25 September 2018

NSW Department of Planning & Environment
GPO Box 39
SYDNEY NSW 2001

**RE: MUDGEE HOSPITAL REDEVELOPMENT (SSD 9211)
ENVIRONMENTAL IMPACT STATEMENT**

TREE REMOVAL SITE PLAN

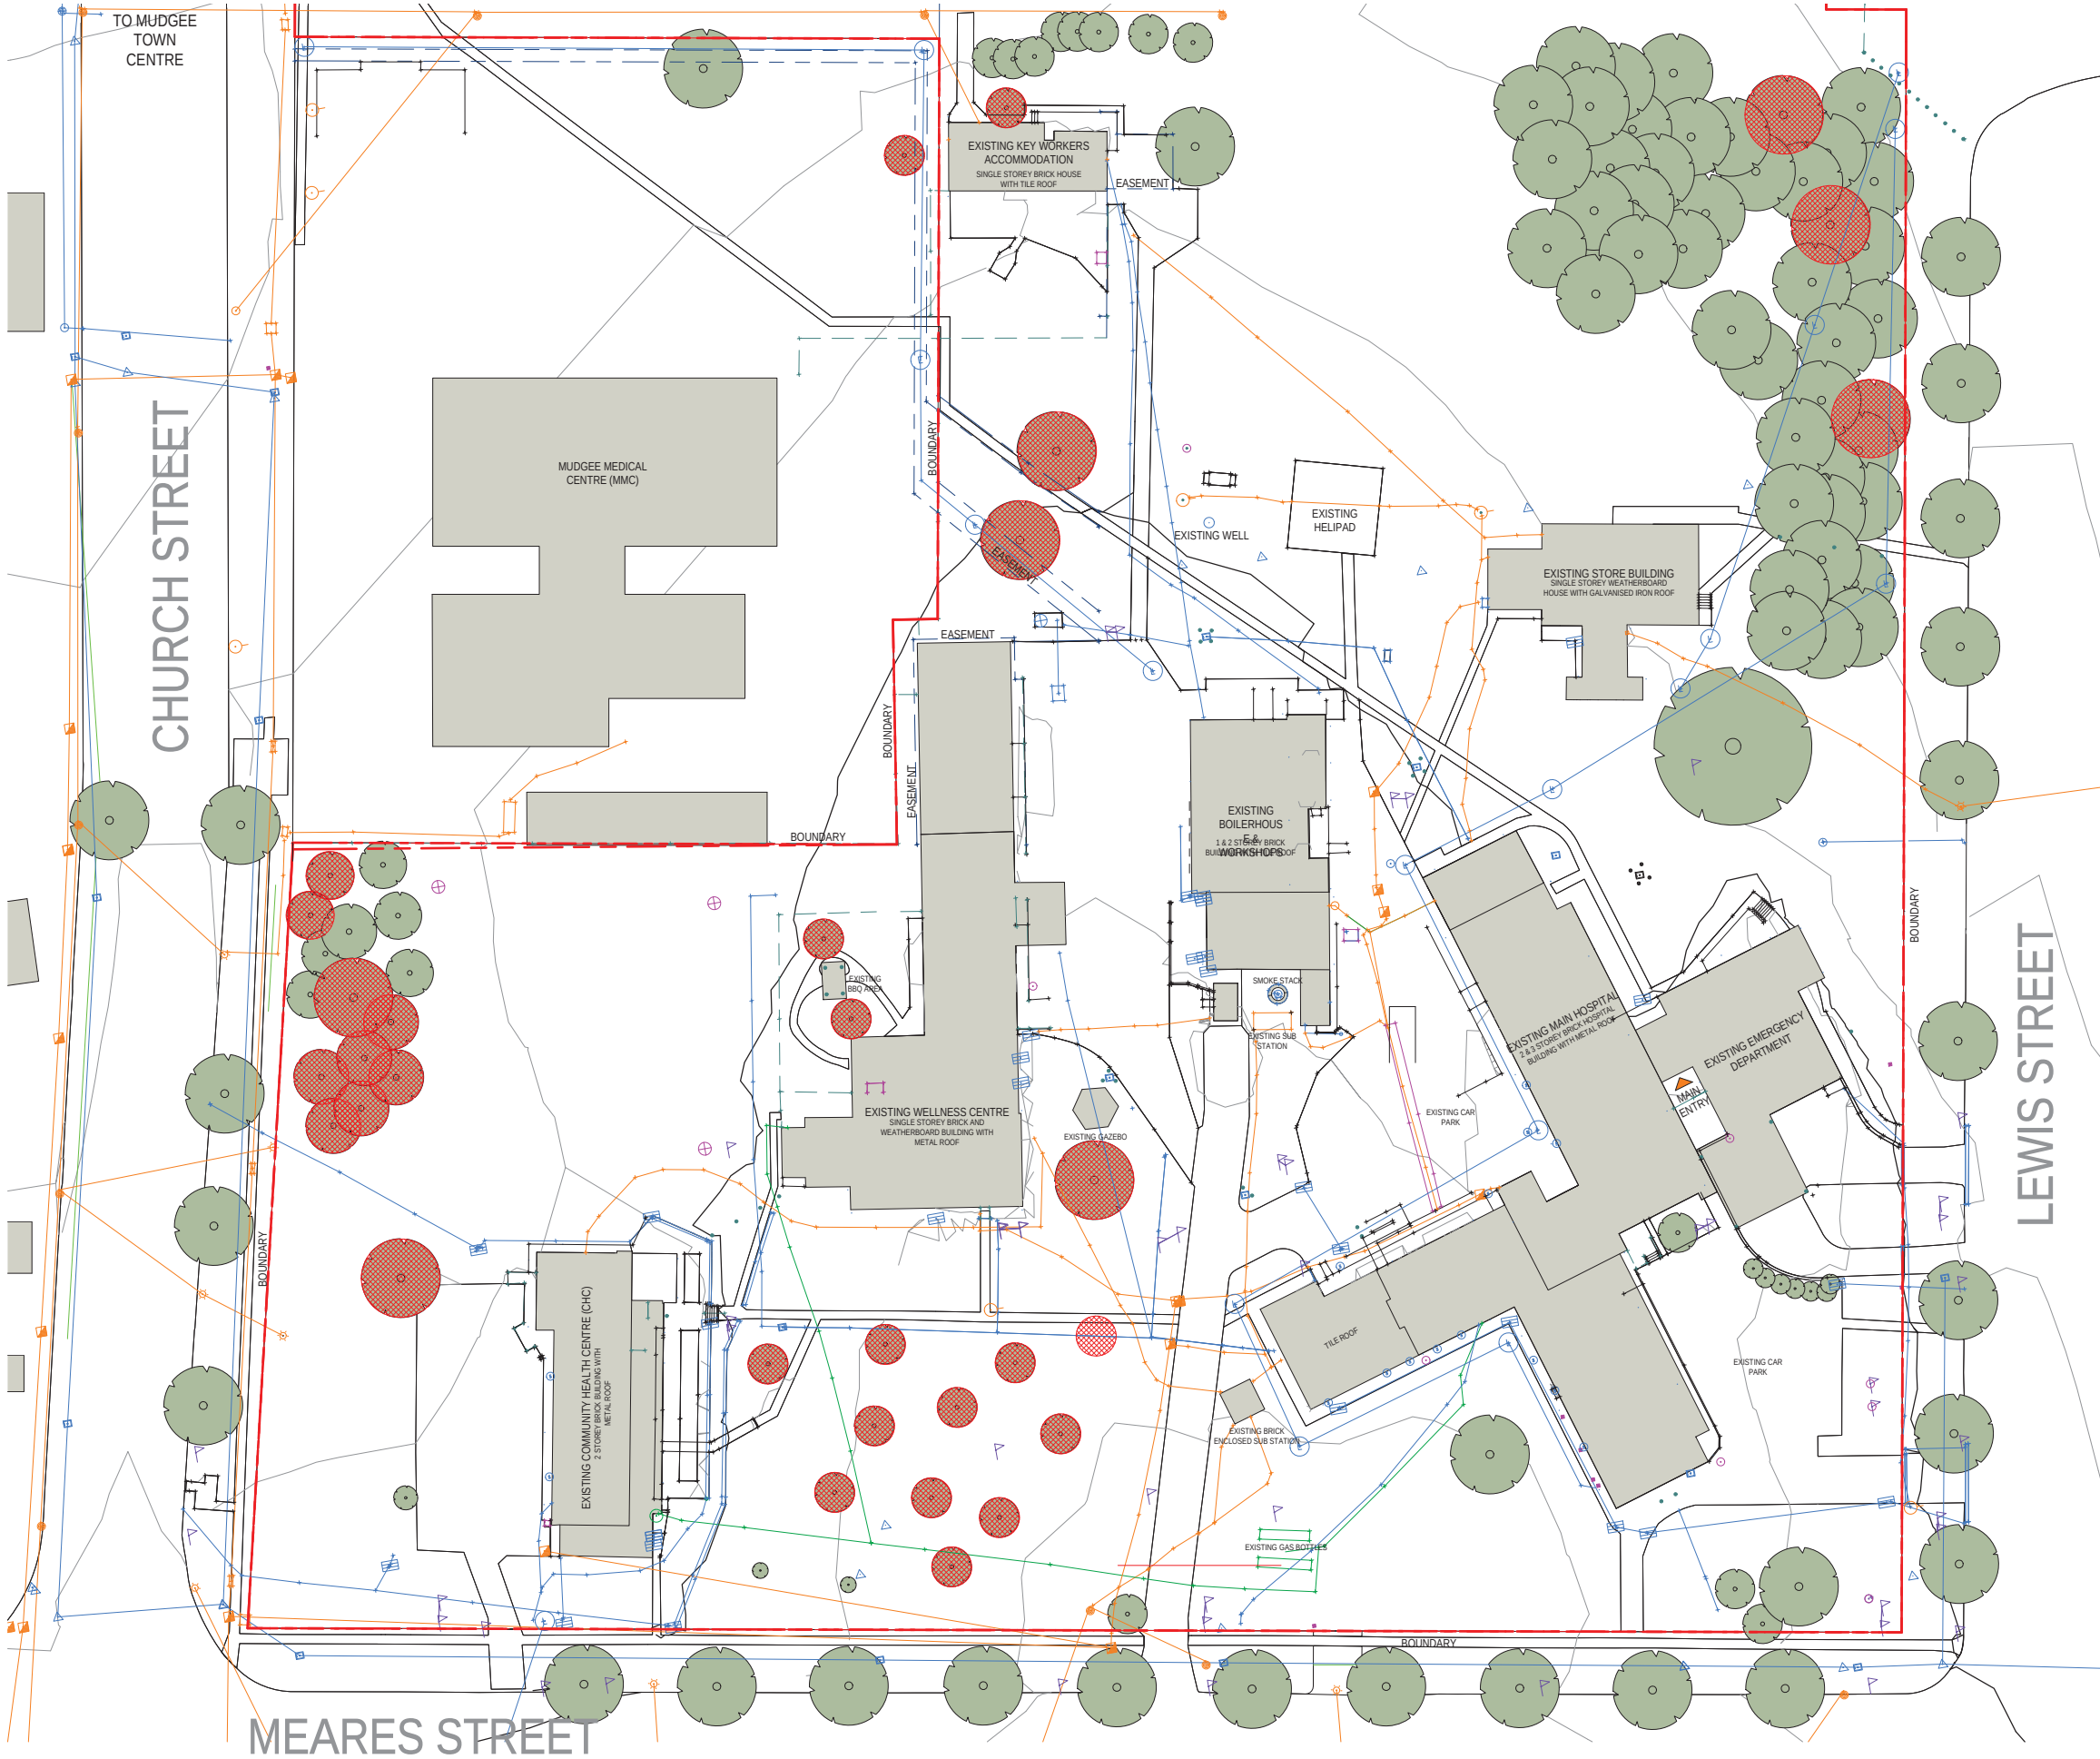
Council understands that twenty six (26) trees located within the proposed building footprint are required to be removed, and six (6) trees outside the building footprint are to be removed for safety concerns. Council acknowledges that trees have been retained where possible.
